Honeycutt Hills Community

Lot 07 – Stonefield 1 Model

AS-BUILT CONDITIONS

M+K Project #: 126-23047 (40/04)

1 1ST FLOOR FRAMING PLAN (CRAWLSPACE)
SCALE: 1/8"=1'-0"

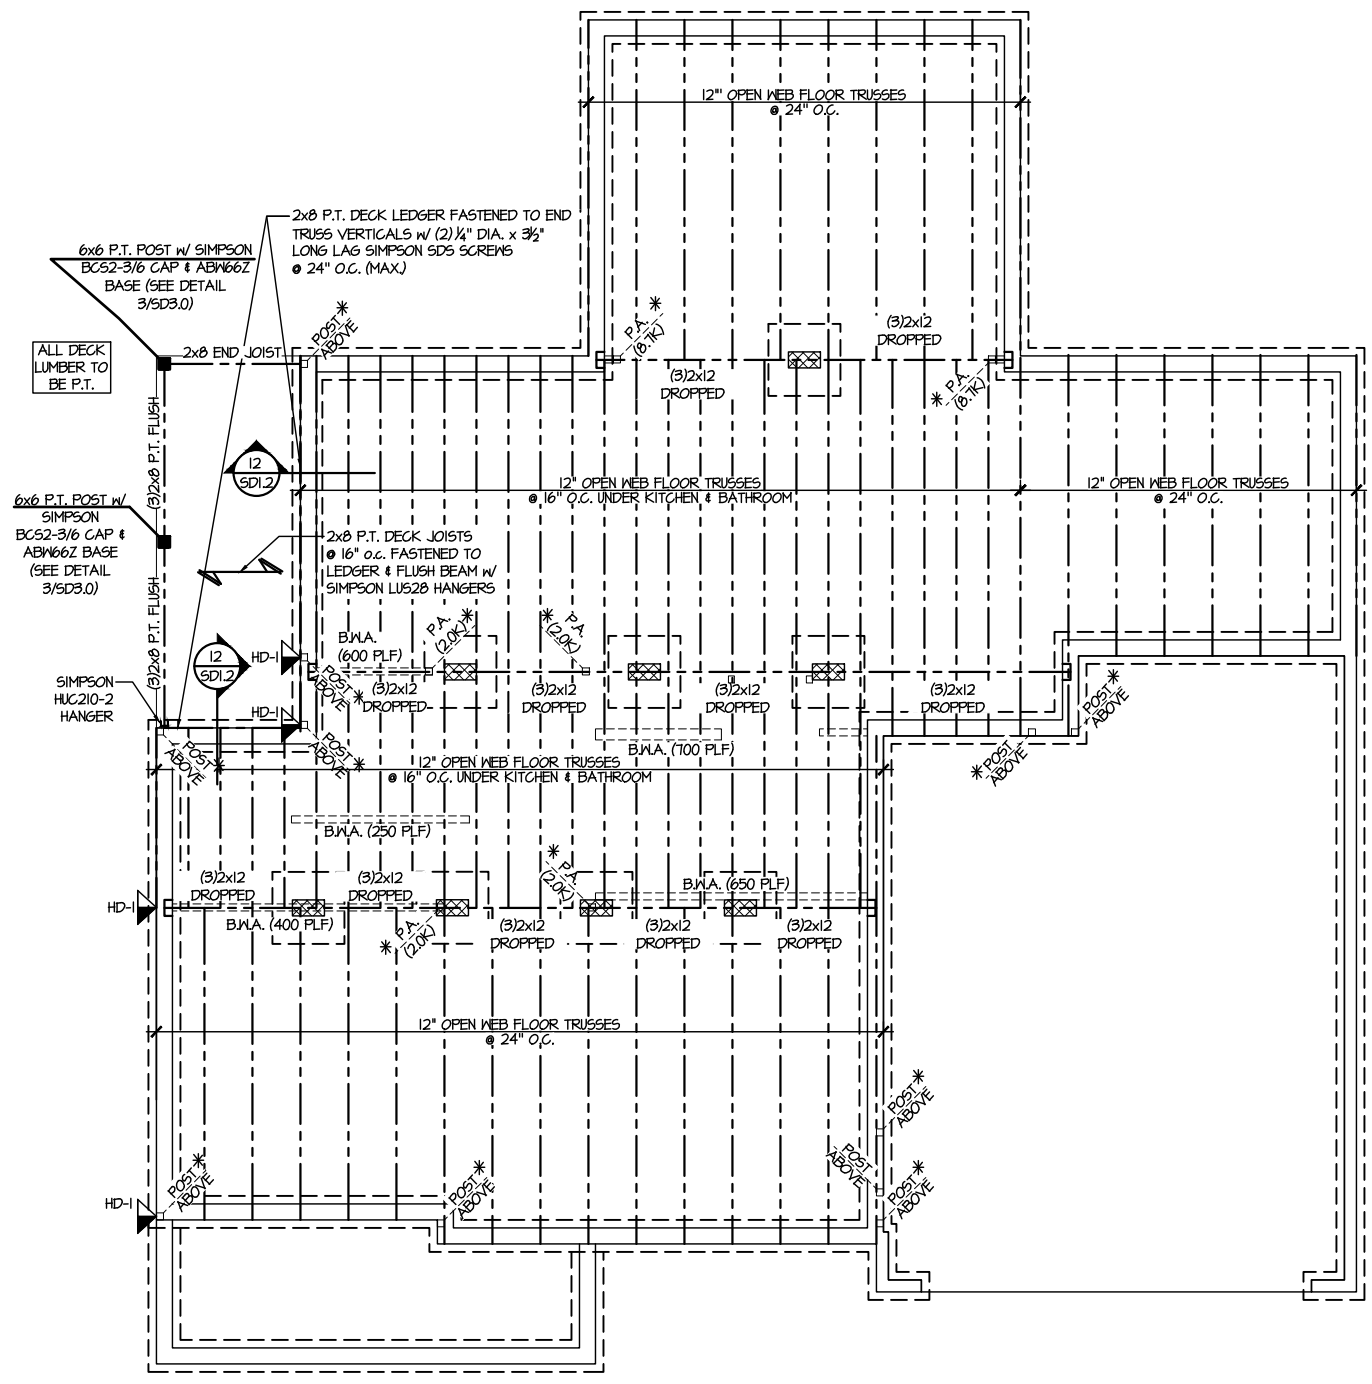
- It was reported to us, by you, that all sets of double or triple windows on the 1st floor were not framed per the structural plans. The structural plans call for (2)2x4 king studs w/ (1)2x4 jack stud each side between each window in a set. Instead, there is only one king stud with a jack on each side between each window.

We have analyzed the as-built condition, and it is our professional opinion that this method is structurally adequate, and no repairs are required.

2ND FLOOR FRAMING PLAN
SCALE: 1/8"=1'-0"

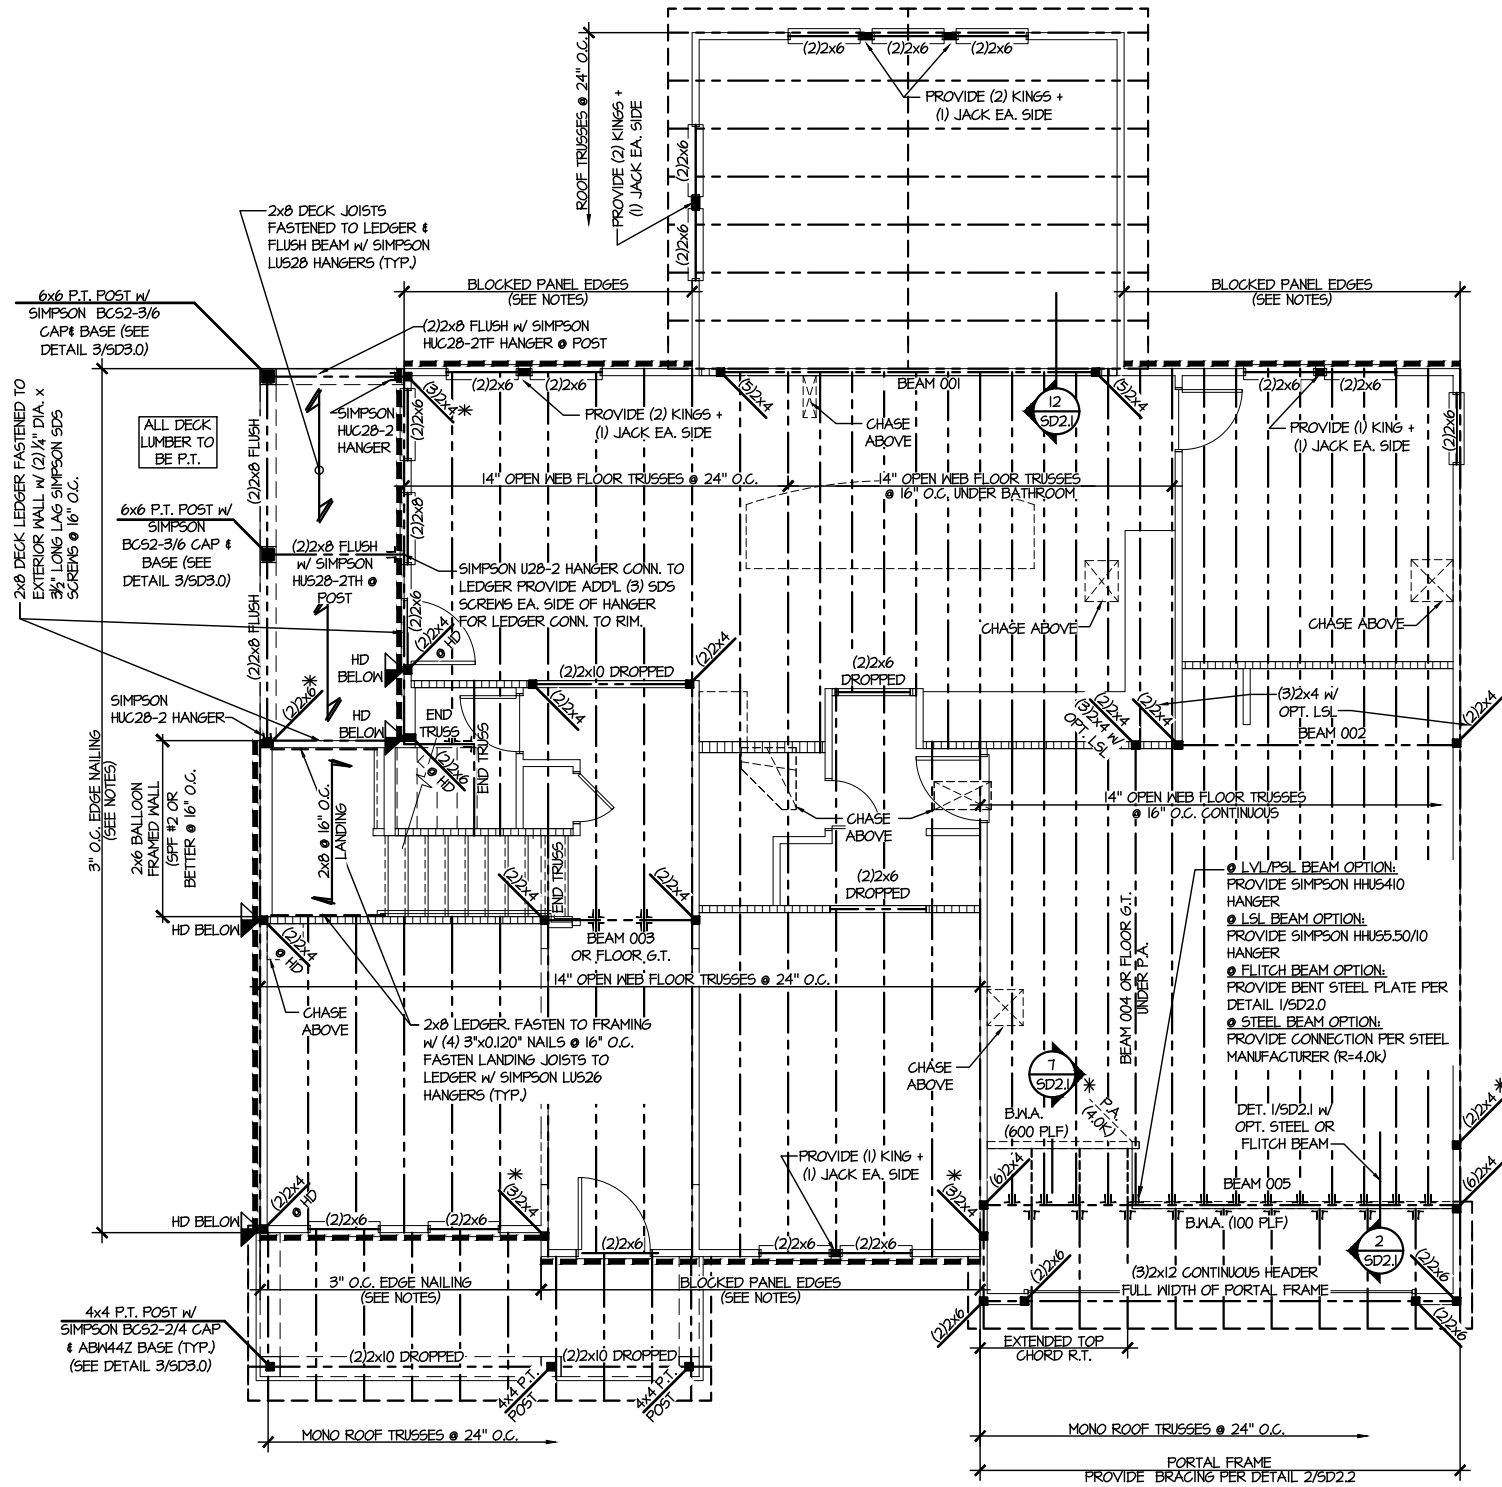
- It was reported to us, by you, that the stair landing was not framed per the structural plans. The structural plans call for 2x8 landing joists fastened to a 2x8 ledger with Simpson LUS26 hangers. Instead, the landing joists were pocketed into the bearing wall. It is our understanding that each 2x8 landing joist has full bearing on a 2x4 bearing wall stud at both ends, directly adjacent to a full height 2x4 bearing wall stud.

We have analyzed the as-built condition, and it is our professional opinion that this method of framing the stair landing is structurally adequate and no repair is required for this condition. Each 2x8 landing joist should be fastened at each end to the adjacent full height 2x4 bearing wall stud with (2) 3" long x 0.120" diameter nails.
